**From:** Jean Fraser  
**To:** Jaegerman, Alex  
**CC:** Barhydt, Barbara  
**Date:** 10/22/2014 12:25 PM  
**Subject:** Update re Dev Rev discussion Fwd: Re: 2282 Congress St - Request To Commence Site Prep  
**Attachments:** Let\_to\_A\_Jaegerman\_10-20-14.pdf; Clearing\_&\_Grading\_Scope\_Fall\_2014.png; Cumberland Ave. 409 - Avesta Housing 7-29-13\_2.pdf

Subject: Re: 2282 Congress St - Request To Commence Site Prep

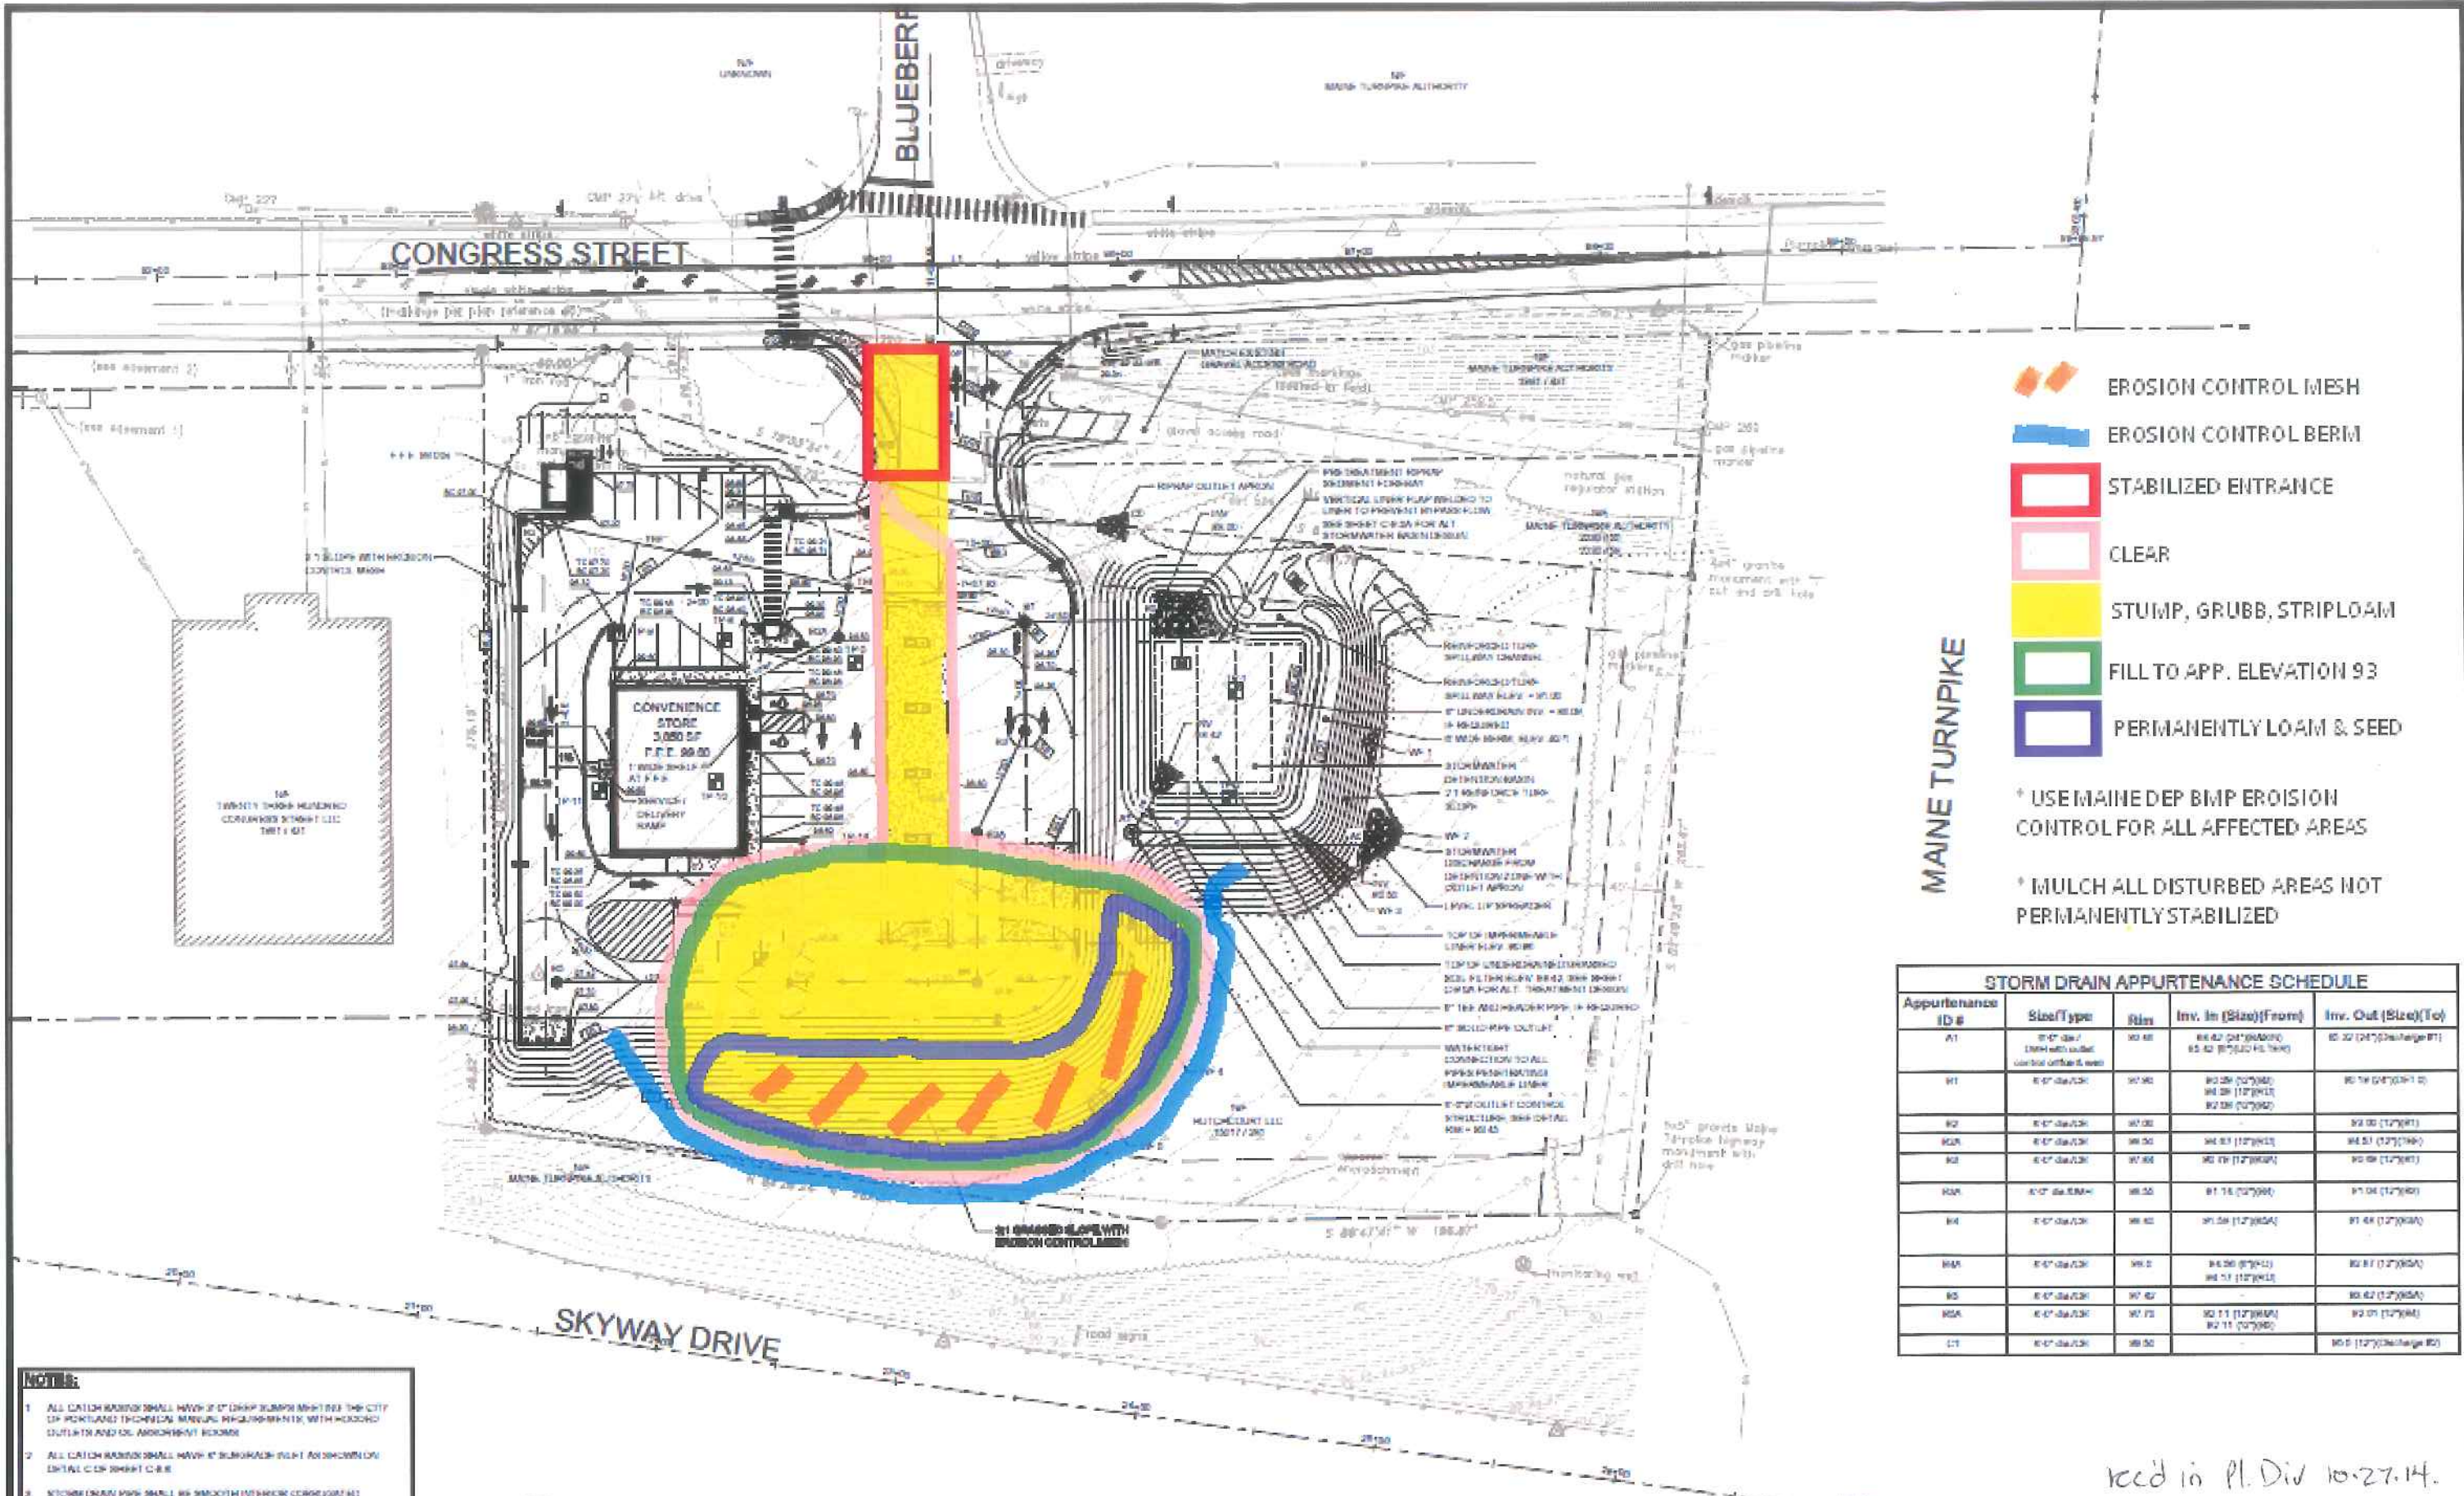
That advance work is effectively limited to the area to be filled where we appreciate some "preloading" is necessary - and would not include clearing of other areas on the site (so the pink line on the attached sketch plan would need to be relocated to the green line) and access for this should avoid any clearing of mature trees; there is a view that removal of the (mature) trees does not improve the site and that if for some reason you don't go forward with the gas station development some other development could be proposed that would include retention of some or all of the trees.

That we are concerned that stabilization and erosion control will be challenging on this site at this time of

year and extra monitoring of erosion control measures will be needed;  
Possible need for clarification of the scale of fill needed and how many trucks might be involved over what period of time (just to assess whether there are any traffic issues).  
The issue of the performance guarantee is still under discussion and I will follow up as soon as possible.
